Planning Application No: 3/2025/0242

Proposal: Proposed single-storey extension to side and rear.

Location: 31 Kenilworth Drive Clitheroe BB7 2QN

Client: Sandra Hogg		
Project: Proposed Alterations 31 Kenilworth Drive Clitheroe		
Dwg title: Proposed Site Plan		
Scale @ A4: 1:200	Date: 20.03.25	Drawn by: PD
Drawing no. 1705 - 102	Rev. -

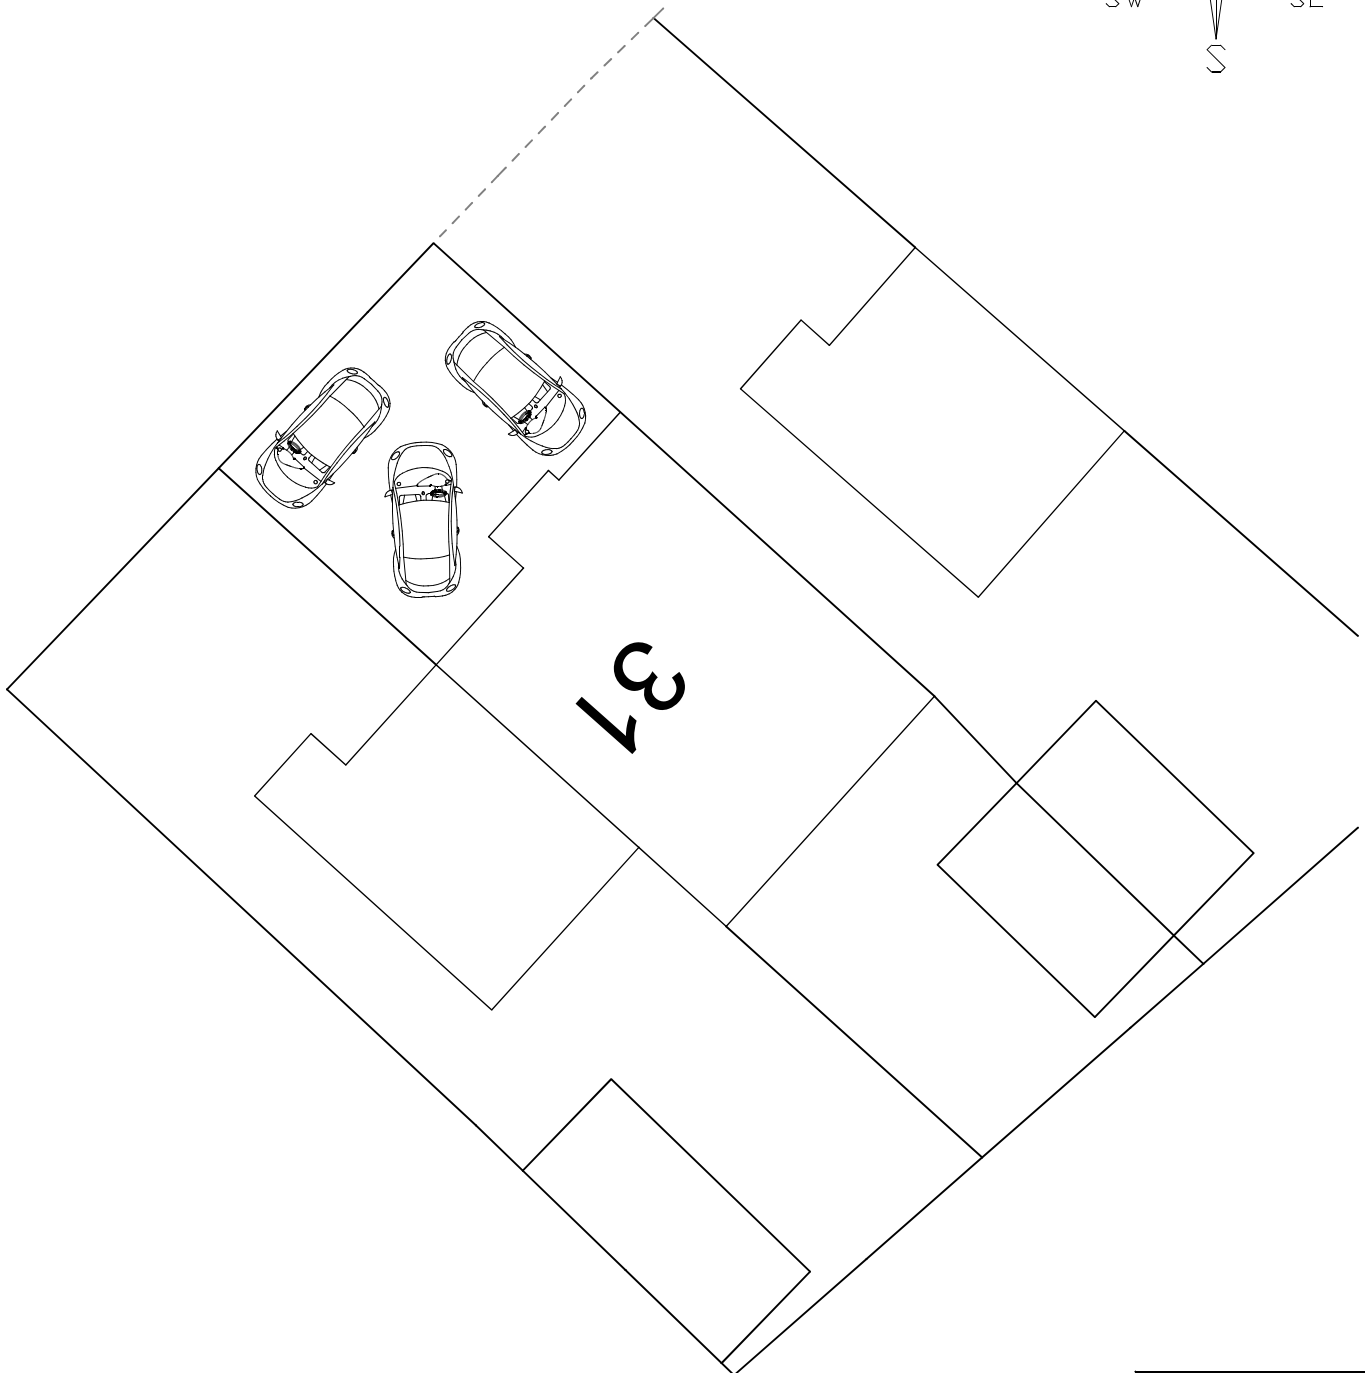
With ref. to the Proposed site plan submitted show that 3 parking spaces as required by parking standards can be met on the drive. However, these need to be side by side.

There is a streetlight, which does not allow for the whole width of the drive to be extended. Therefore, a small 1m wall or fence should be erected on the property to protect the streetlight. (Ref. CR no. 00659662) Our Engineer has spoken to the homeowner and explained the request for protection of the streetlight.

An amended plan is required to show this. There is no objection subject to the following:

- The parking areas must be constructed of a bound porous material and created before first occupation up until the lifetime of the dwelling existing in its proposed state. Reason: To ensure that satisfactory parking is provided before the dwelling hereby permitted becomes operative.
